Development Application Permit Review

COMMUNITY SERVICES DEPARTMENT

July 11, 2019

Name:	Walden Preserve 2 Filing No. 4 Final Plat	Application Type:	Final Plat
PCD Reference #:	SF-1834	Total Acreage:	45.27
		Total # of Dwelling Units:	23
Applicant / Owner:	Owner's Representative:	Dwelling Units Per 2.5 Acres:	1.27
Walden Holdings I, LLC	LRA	Regional Park Area:	2
Matt Dunston	David Jones	Urban Park Area:	1
17145 Colonial Park Drive	9736 Mountain Road	Existing Zoning Code:	PUD
Monument, CO 80132	Cascade, CO 80809	Proposed Zoning Code:	PUD

DRAWING: 17094FP4.DWG PAGE 1 OF 2

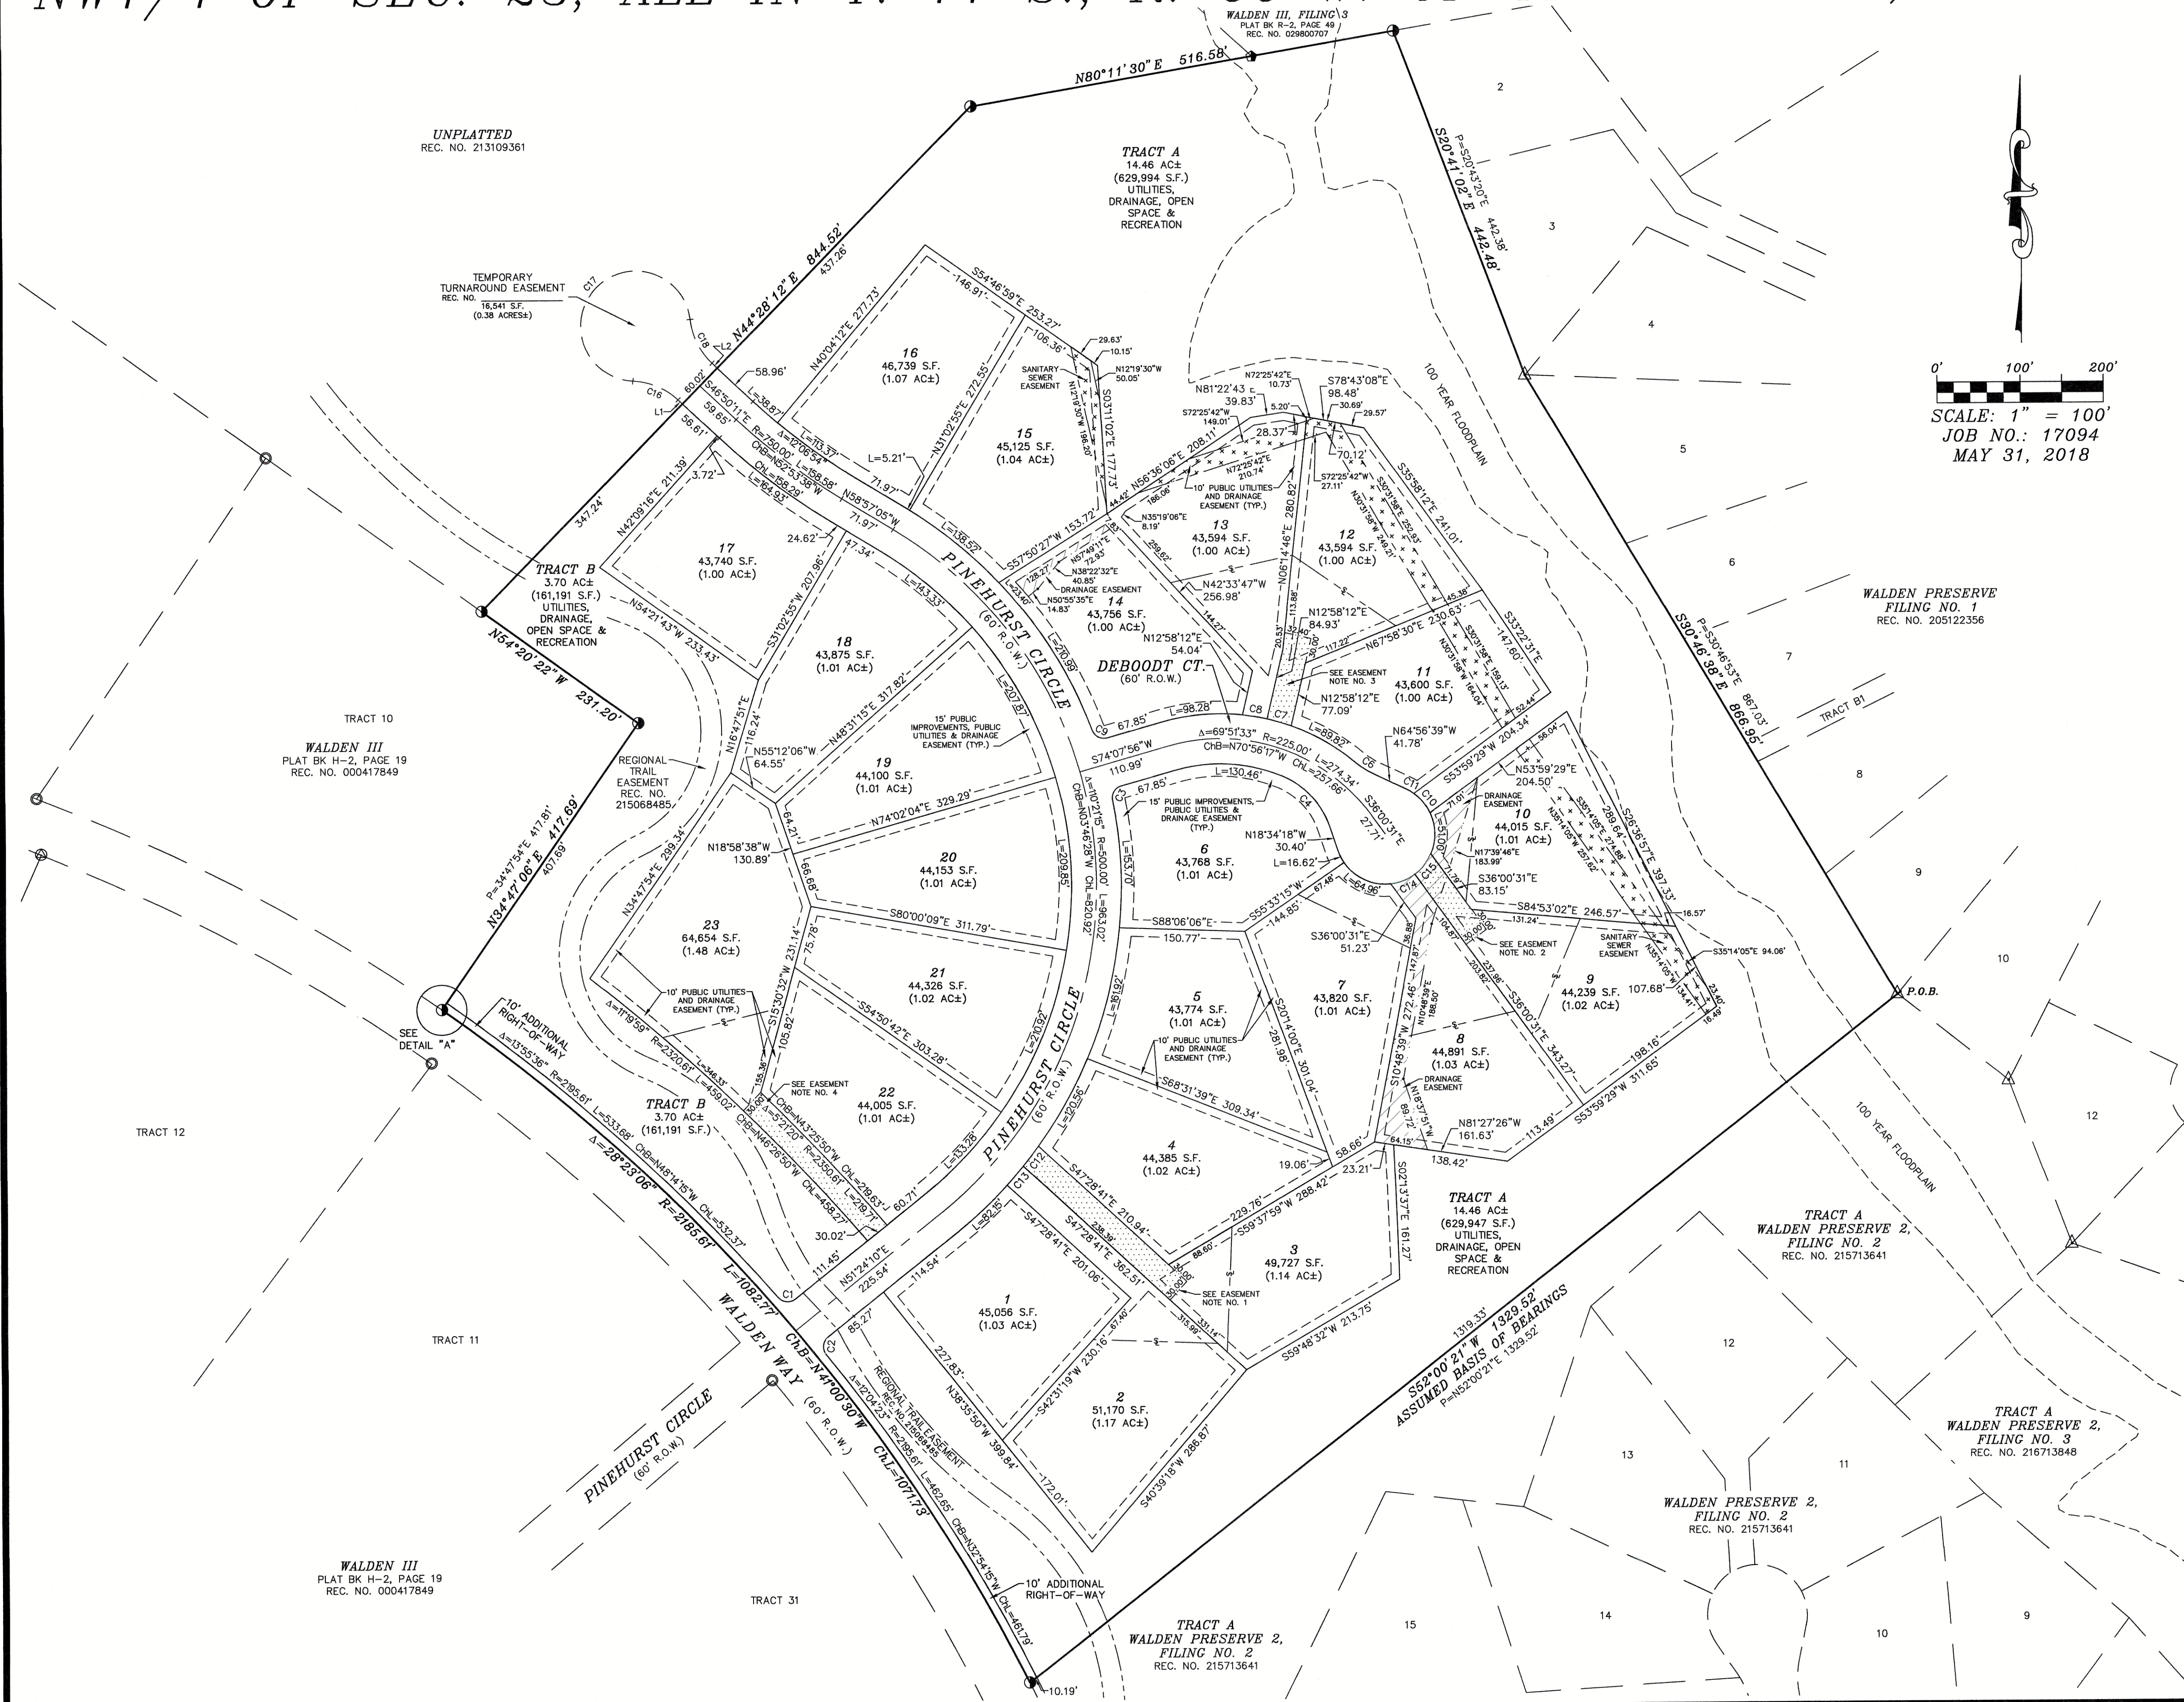
Staff Recommendation: Recommend to the Planning Commission and Board of County Commissioners that approval of the Walden Preserve 2 Filing No. 4 Final Plat include the following conditions: (1) Show the 25 foot public trail easement for the Cherry Creek Regional Trail within Tract A and Tract B; (2) Required regional and urban park fees are credited per a Park Lands Agreement.
